An
Bord
Pleanála

Inspector's Report

ABP-317874-23

Extraction of sand and gravel from quarry. An Environmental Impact Assessment Report (EIAR) and a Natura Impact Statement (NIS) have been submitted.

Restoration Phase 4
Extraction Phase: 5
Years: 8-10

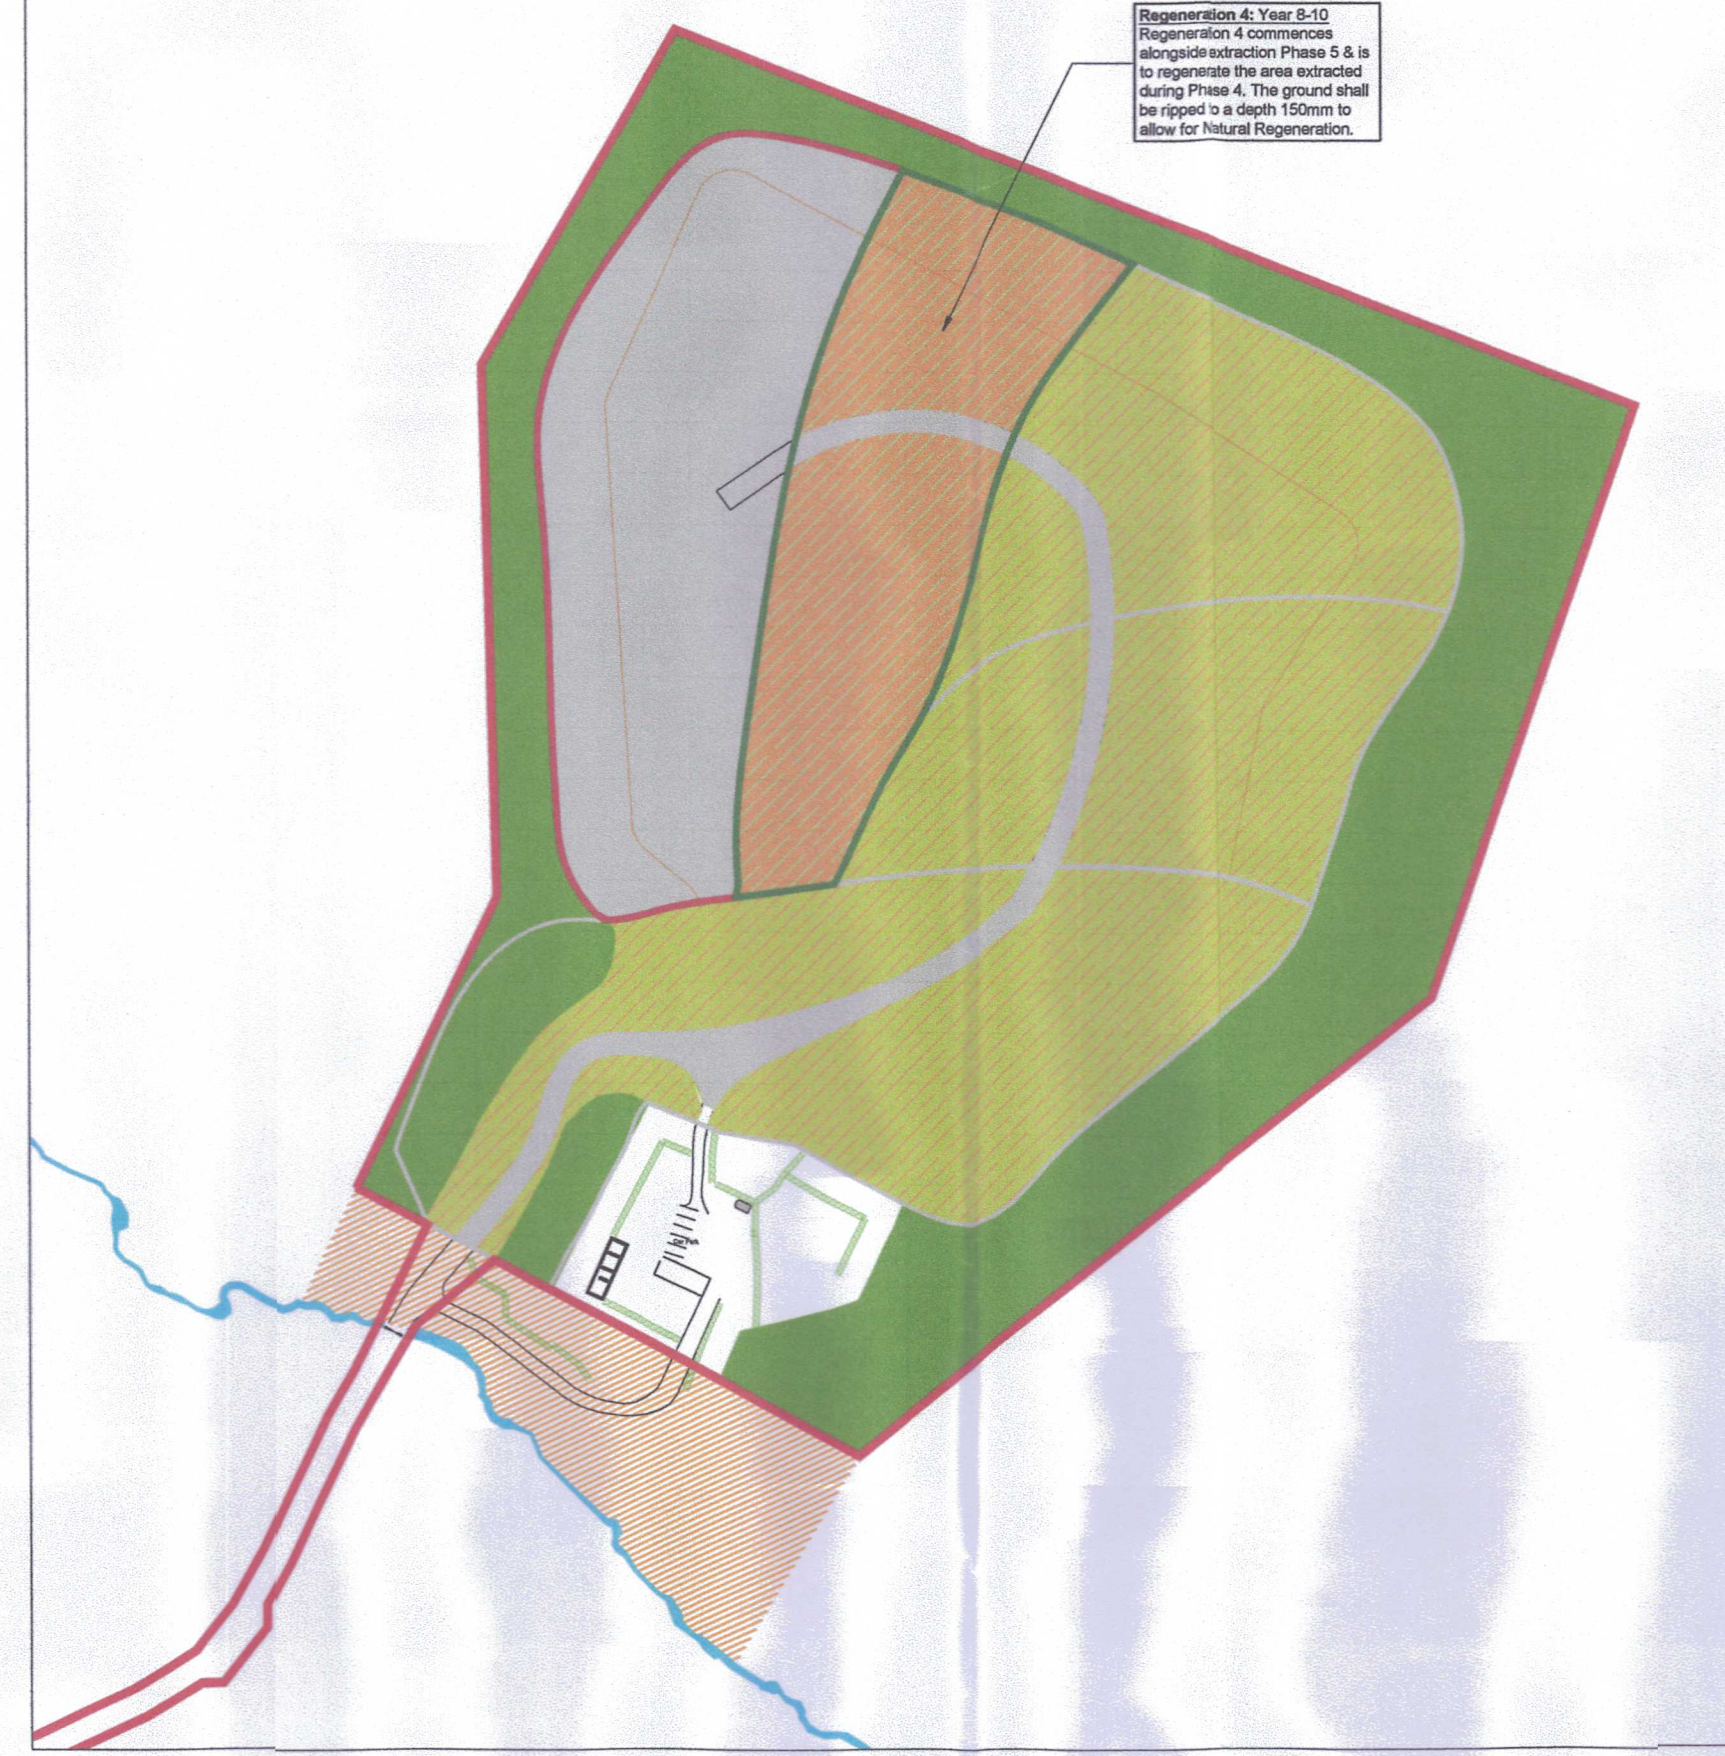
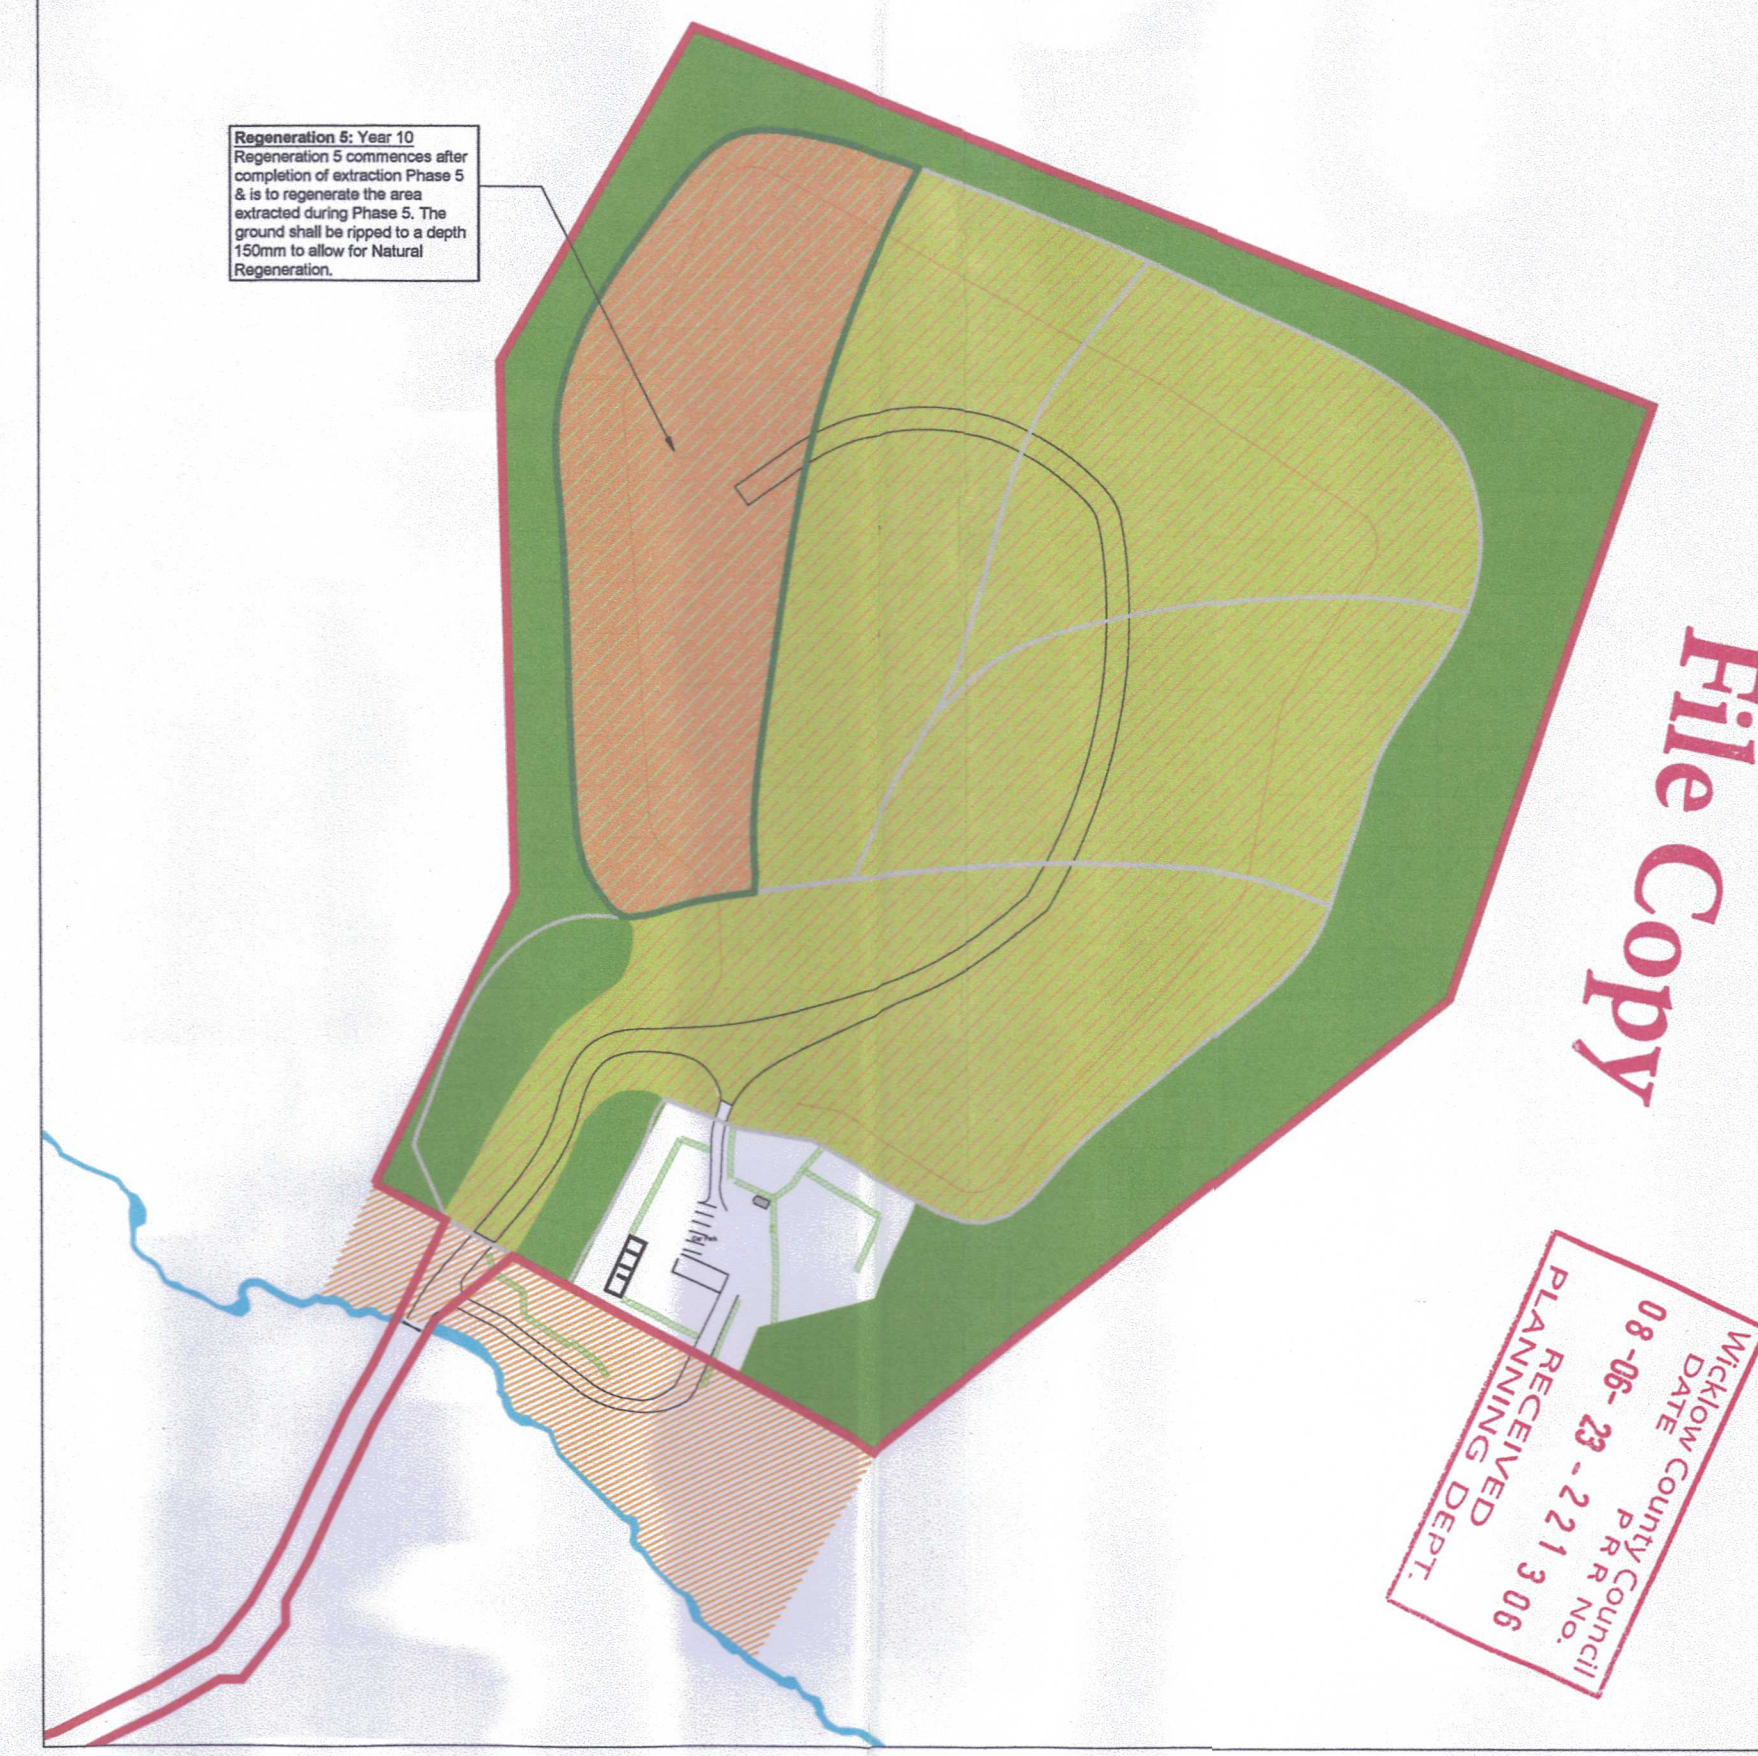
3.2.1.4. Within their response document (Part 1), the Applicant noted that there had been a change in the project description, and it was now proposed that restoration activities will be phased and happen concurrently with the phasing of extraction activities. A sequencing of the restoration phase compared to the extraction phasing is set out in Table 2-1 of their response document and they referred to the Updated Restoration Plan that accompanied their response. In addition to the supplementary assessments

DRAWING NO:
AI-01

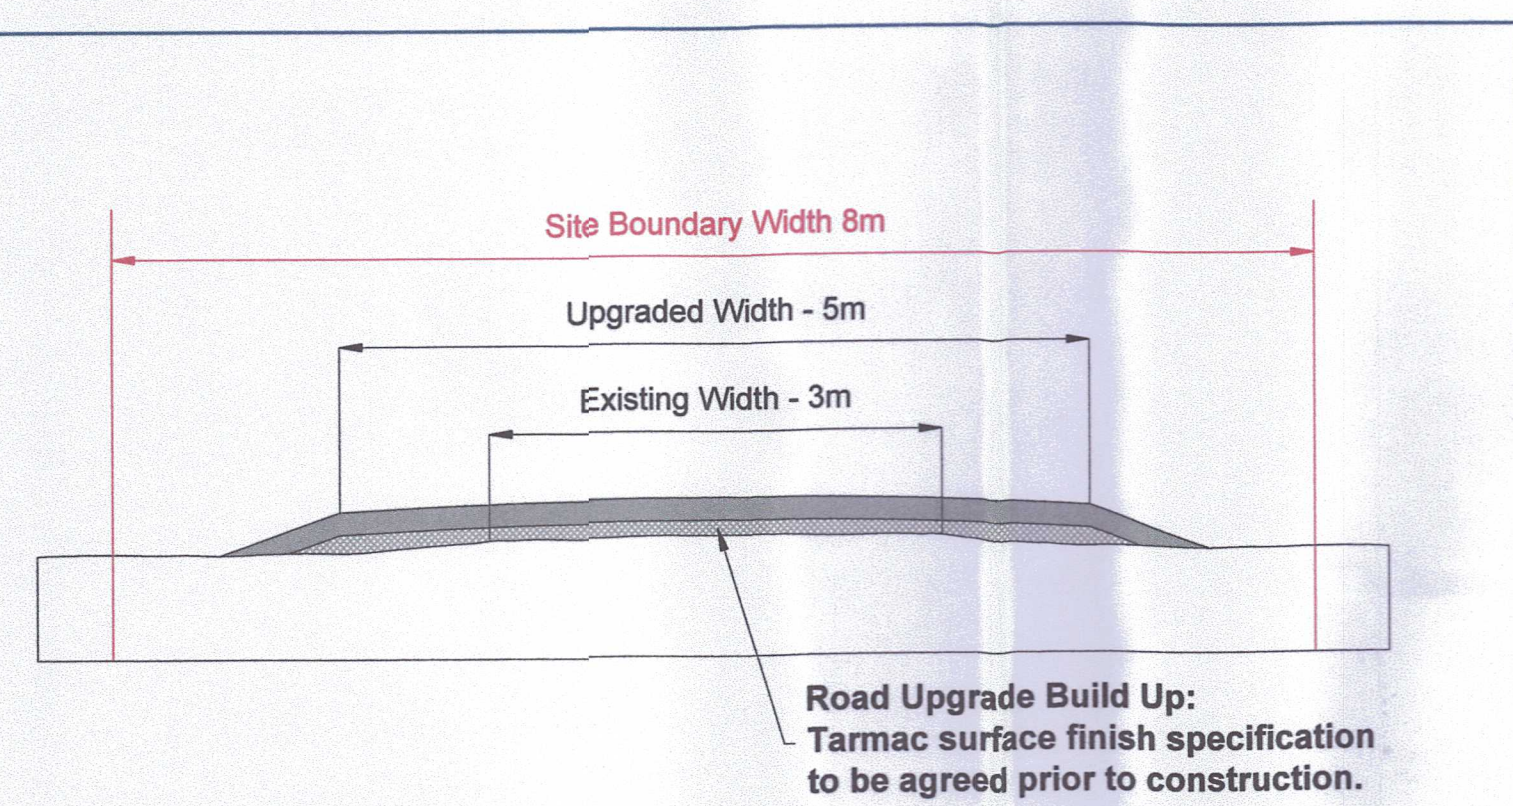
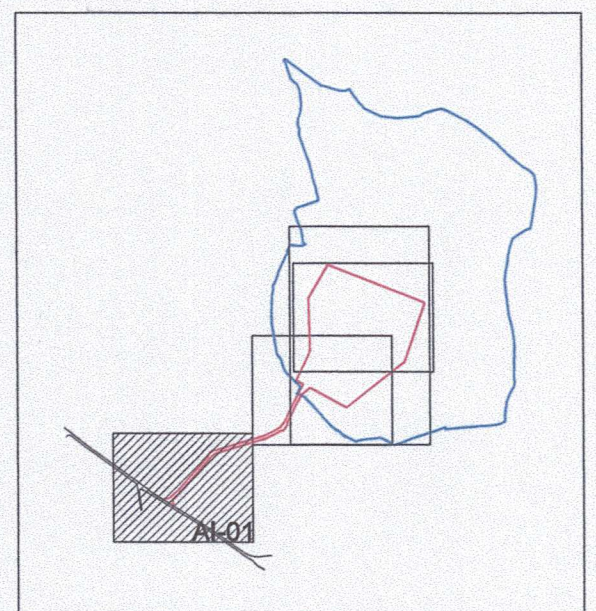
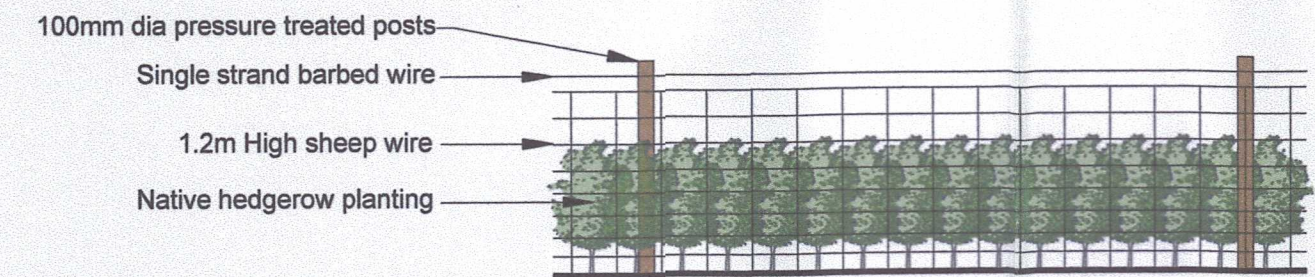
- Updated plans to remove the hedgerows/trees on either side of the proposed entrance to facilitate adequate sightlines. (letter of consent from landowner attached)
